# FIVE ESTUARIES OFFSHORE WIND FARM

## 10.58 APPLICANT'S RESPONSES TO EXQ3

Application Reference:	EN010115
Document Number:	10.58
Revision:	A
Pursuant to:	Deadline 7
Eco-Doc Number:	005711025-01
Date:	March 2025

Figure 2.1: Overview of area of interest for NIP (including concurrent activity areas).

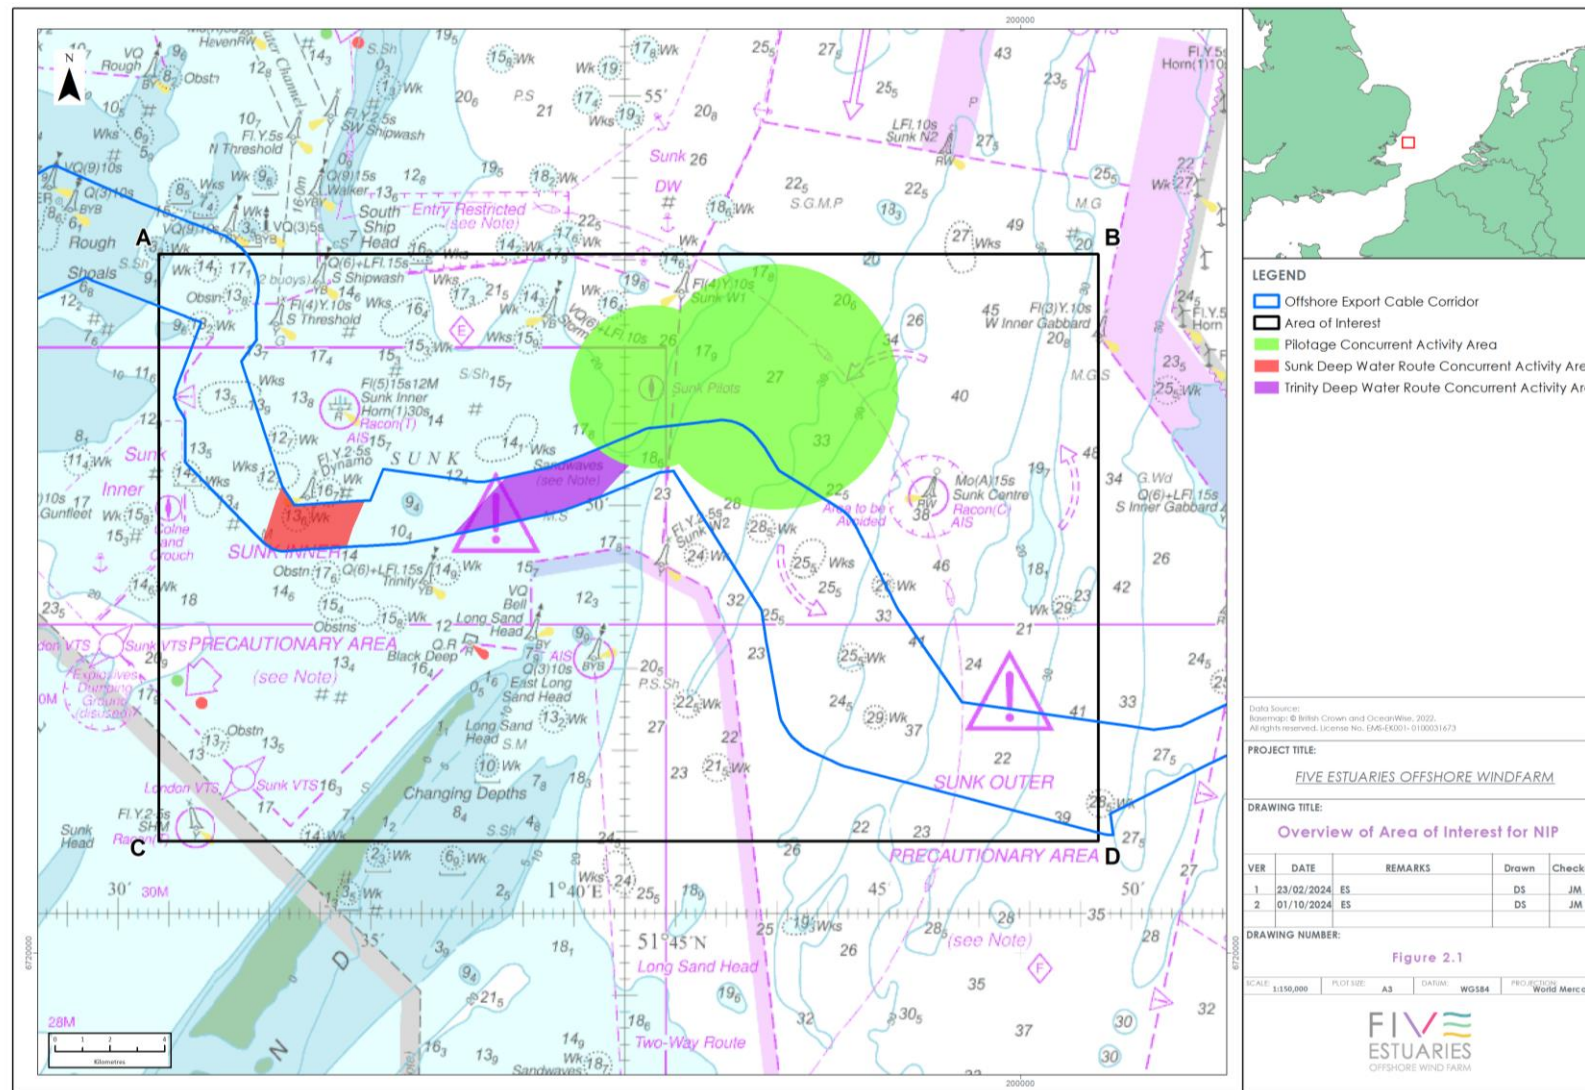
Ref	Question to:	Question	Applicant's response
NS.3.01	Applicant	<p><b>Figure 2.1 in the Outline Cable Specification and Installation Plan (OCSIP)</b></p> <p>The amended version of the OCSIP submitted at Deadline 4 [REP4-019] at various points refers to Figure 2.1. That figure is included as page 16 of the OCSIP but has not been titled as such. Commitments included in the OCSIP rely on what is shown on Figure 2.1, accordingly for the avoidance of doubt and for ease of use when the OCSIP is next updated the figure included on page 16 should be clearly titled as Figure 2.1.</p>	<p>The Applicant has amended the Outline Cable Specification and Installation Plan (OCSIP) [REP6-020] with Figure 2.1 clearly titled in Revision C, which was submitted at Deadline 6.</p>
NS.3.02	Applicant	<p><b>Pre-construction activities within the Deep Water Routes (DWR)</b></p> <p>During Issue Specific Hearing 6, you advised that the Outline Navigation and Installation Plan [REP5-031] was not the appropriate mechanism to control pre-construction activities within DWRs, as had been requested previously by the PLA. Please explain how you intend to provide comfort to the Ports and Port Authorities that any pre-construction activities could be carried out safely and without delaying scheduled commercial vessels using the DWRs.</p>	<p>The Applicant has provided this commitment in the draft protective provisions for the benefit of the PLA. These require early engagement and consultation on the planning of such surveys.</p>
